Thank you for the opportunity to comment on the Star View Short Plat (SP-08-00039). In order to meet the requirements set forth by Kittitas County Public Health's Environmental Health Division and Kittitas County Code Chapter 13, the following items must be submitted:

STAR VIEW SHORT PLAT
KITTITAS COUNTY SHORT PLAT NO. 08-XX
PORTION OF THE SW 1/4, SEC. 09, T.20N., R.15E., W.M.
KITTITAS COUNTY, WASHINGTON

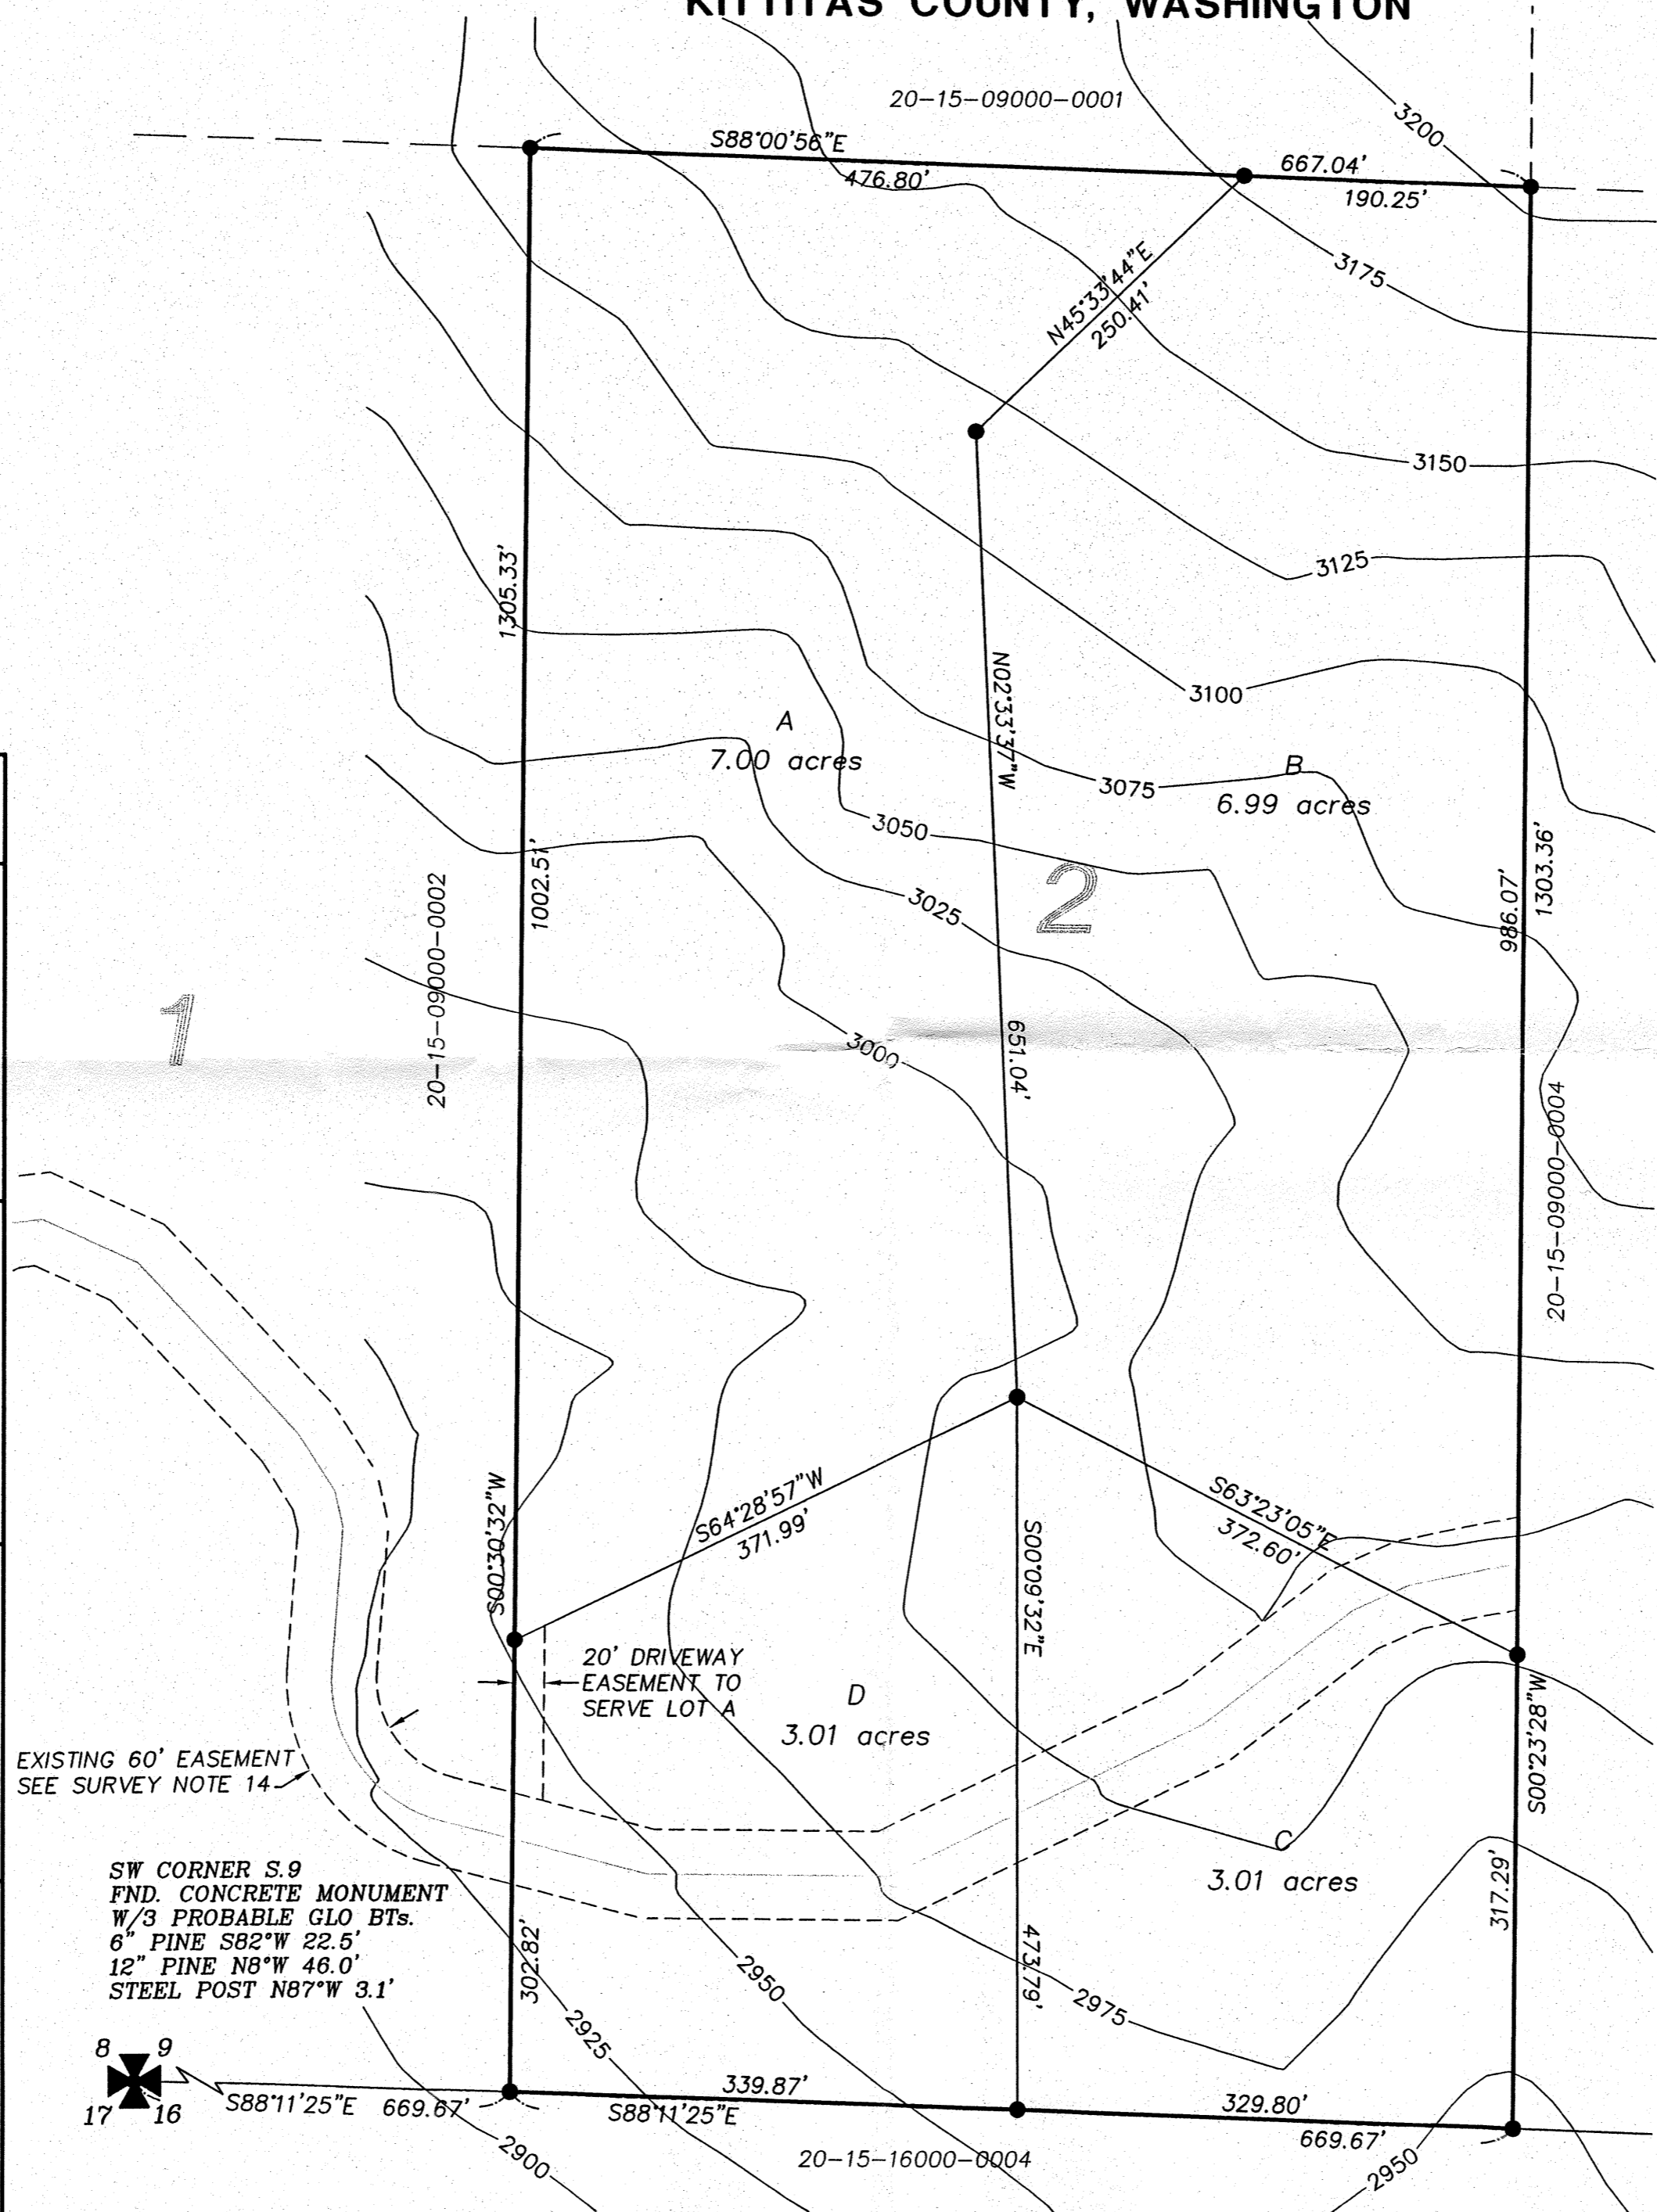
- The Star View Preliminary Plat No. SP-08-00039 currently has 5000 gallons of water per day for all domestic uses from the domestic well use exemption. According to WAC 173-539A each lot of this plat is allowed no more than 1250 gallons per day per lot.

- *The following plat notes shall be included on the final mylar:*
 1. "The approval of this division of land includes no guarantee that there is a legal right to withdraw groundwater within the land division. The approval of this division of land provides no guarantee that use of water under the ground water exemption (RCW 90.44.050) for this plat or any portion thereof will not be subject to curtailment by the Department of Ecology or a court of law."
